Brendan Liew - Modification Application - 08_0016 Mod 1

Our Ref: IMS3838186

Re: Modification of Application for Printing Warehouse and Distribution Facilities at 133-145 Lenore Drive Erskine Park

**SITE PLAN**

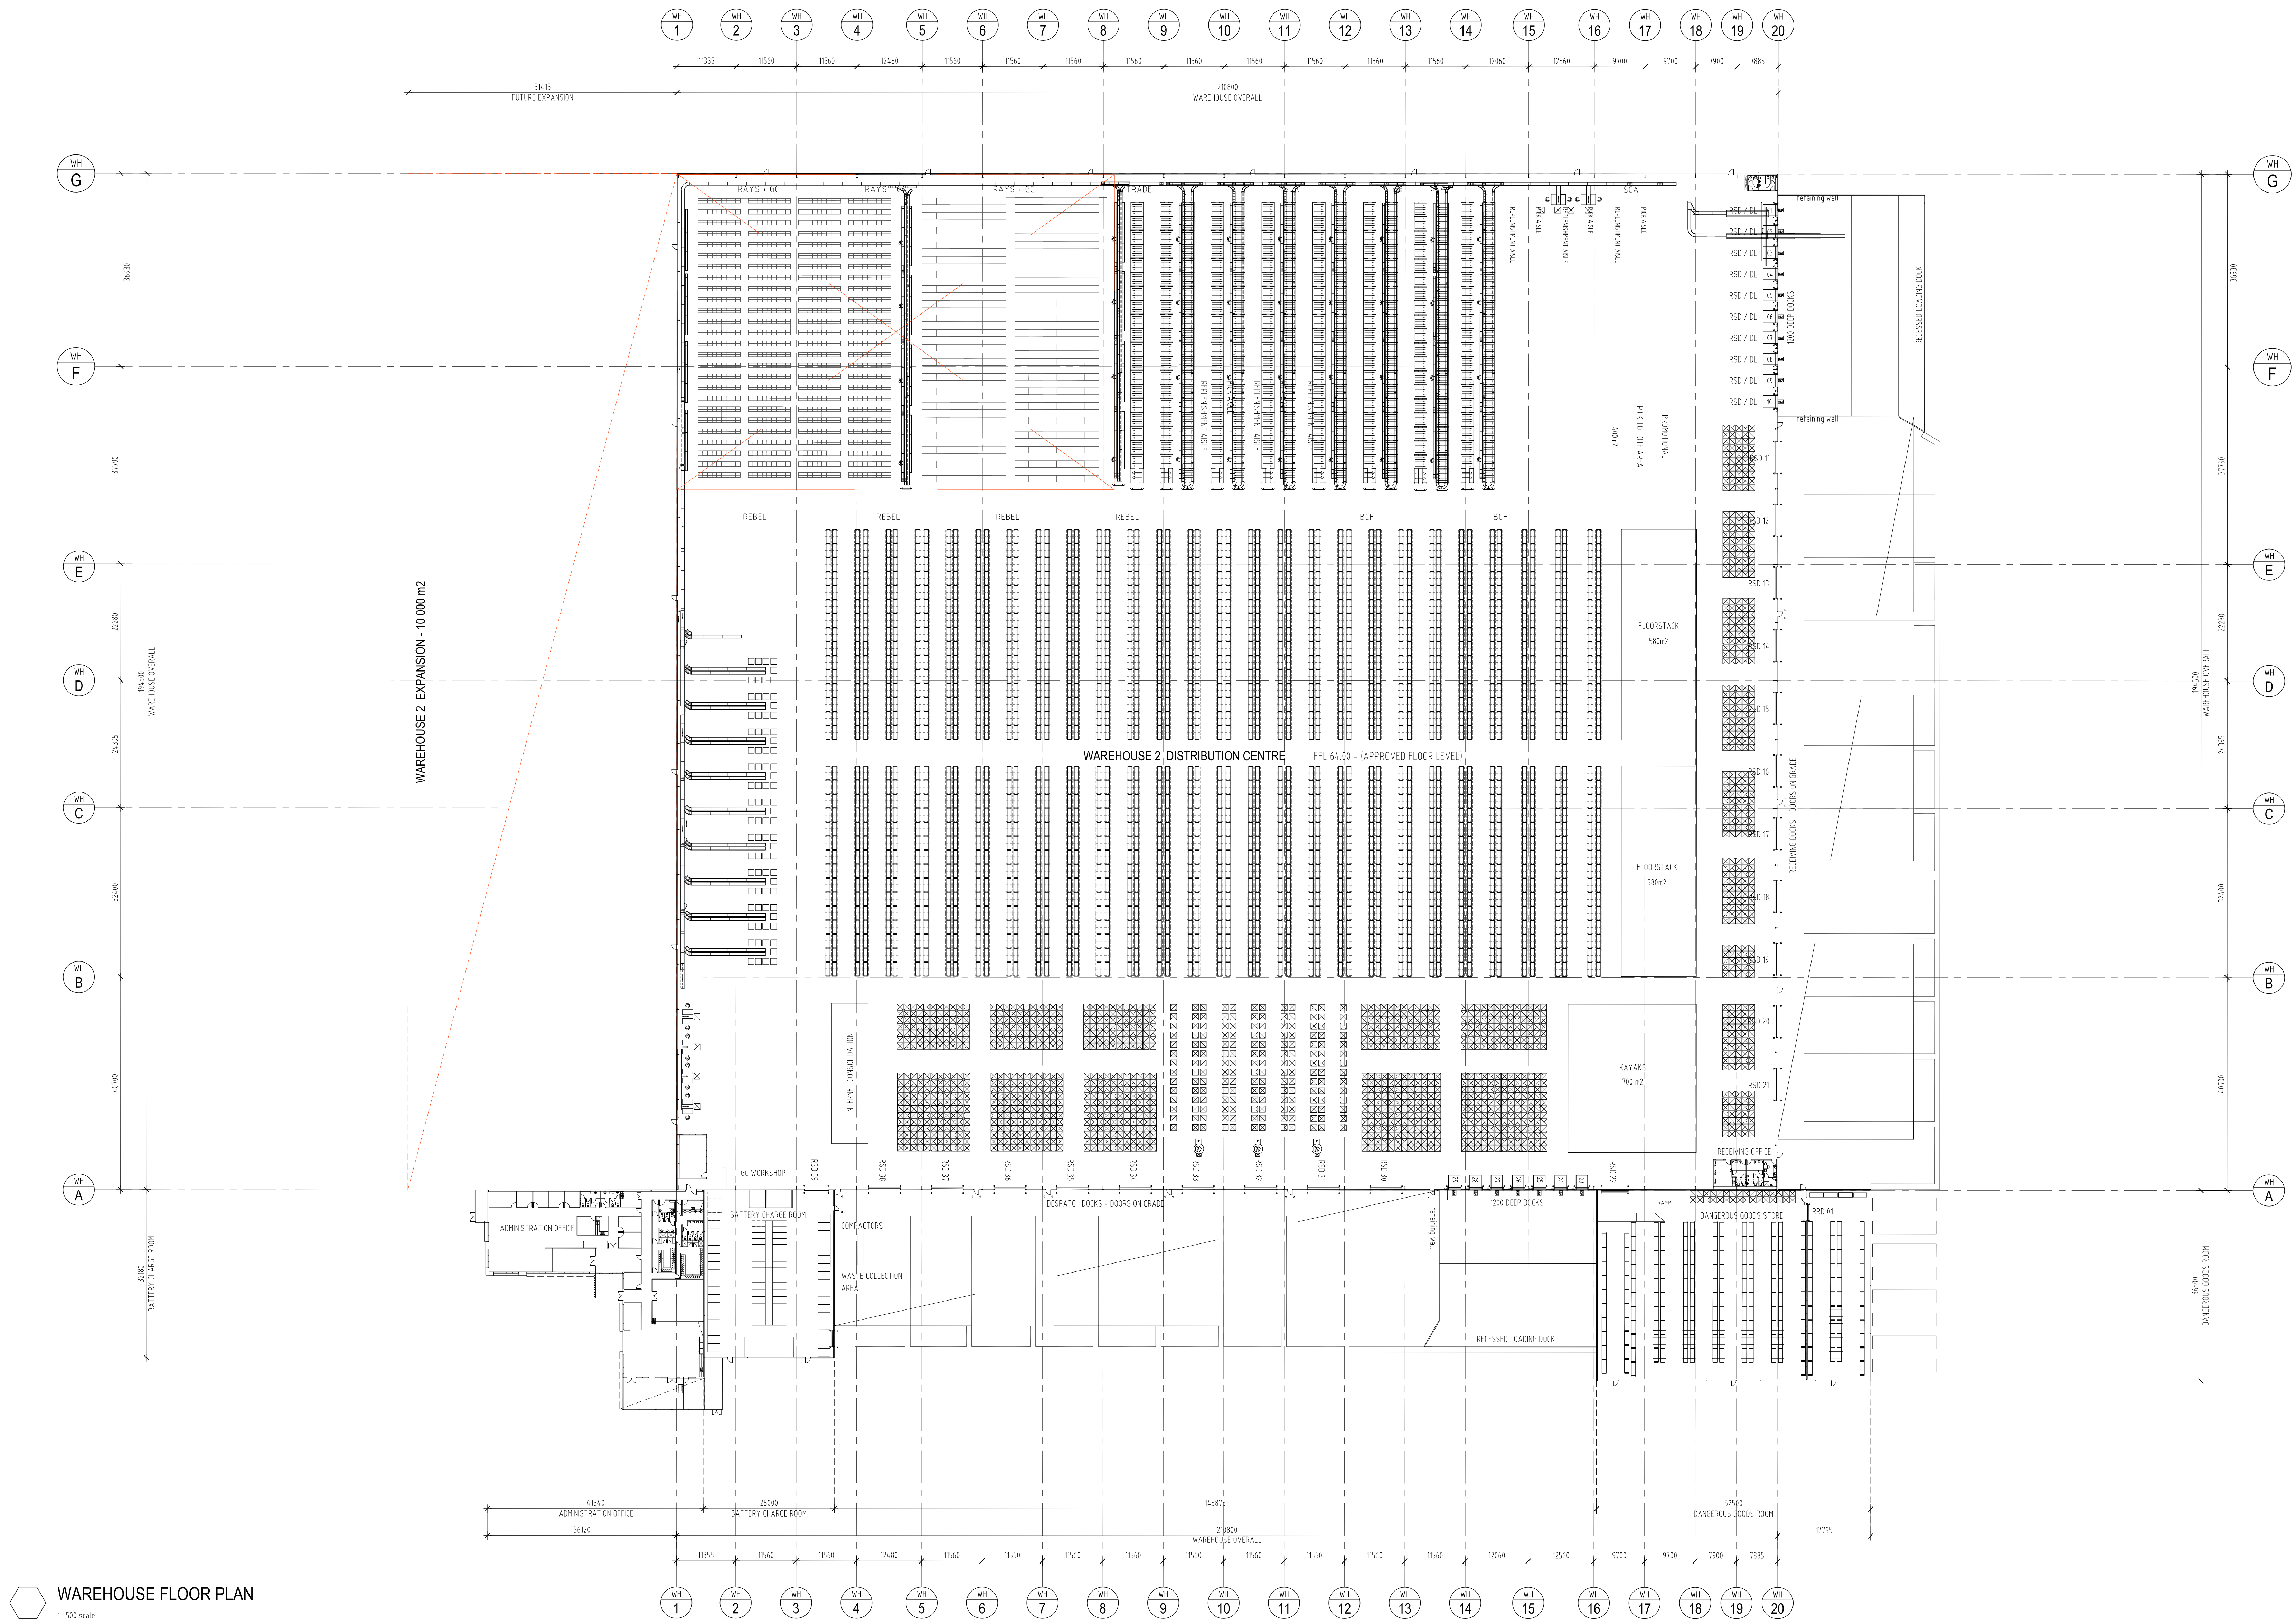
- *Site Configuration* - The new proposal presents a poorer outcome in terms of presentation and setbacks to the northern and western boundaries. BCA compliance and NSW firebrigade acceptance of the reduced setback of the building to the western boundary, which appears to limit perimeter access, should be confirmed. The location of loading/unloading docks on the northern boundary presents concerns regarding acoustic impacts, visual amenity and lighting impacts on residents adjoining to the north.

Figure 3-1: Dangerous Goods Store Layout

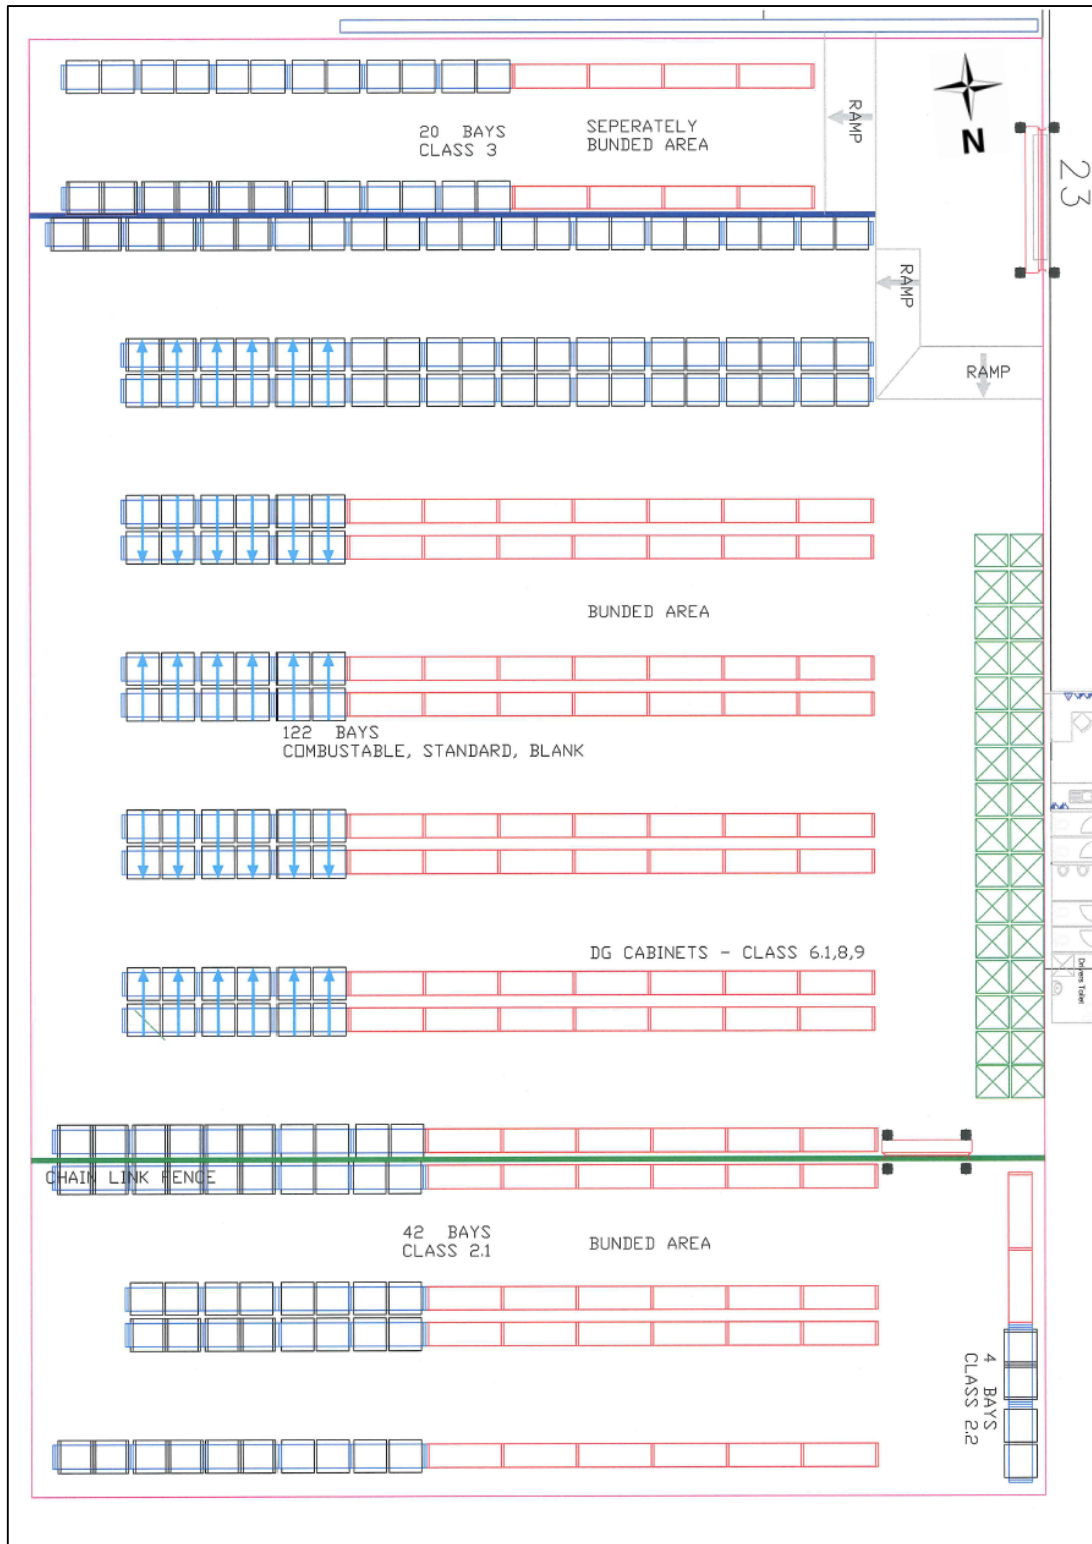
- *State Environmental Planning Policy No. 33 – Hazardous and Offensive Development* – The modification proposes to increase the amount of Dangerous Goods stored on the premises. On review of the Preliminary Hazard Analysis (PHA) submitted by the applicant, it appears that sufficient mitigation measures will be implemented to ensure that the development will not be hazardous or offensive. In this regard, suitable conditions should be applied to ensure that only those maximum quantities and classes of Dangerous Goods as assessed in the PHA are permitted on the site, and that the recommendations of the PHA are included as a part of the approval (particularly the

development of environmental procedures as per Section 5 and Section 6).
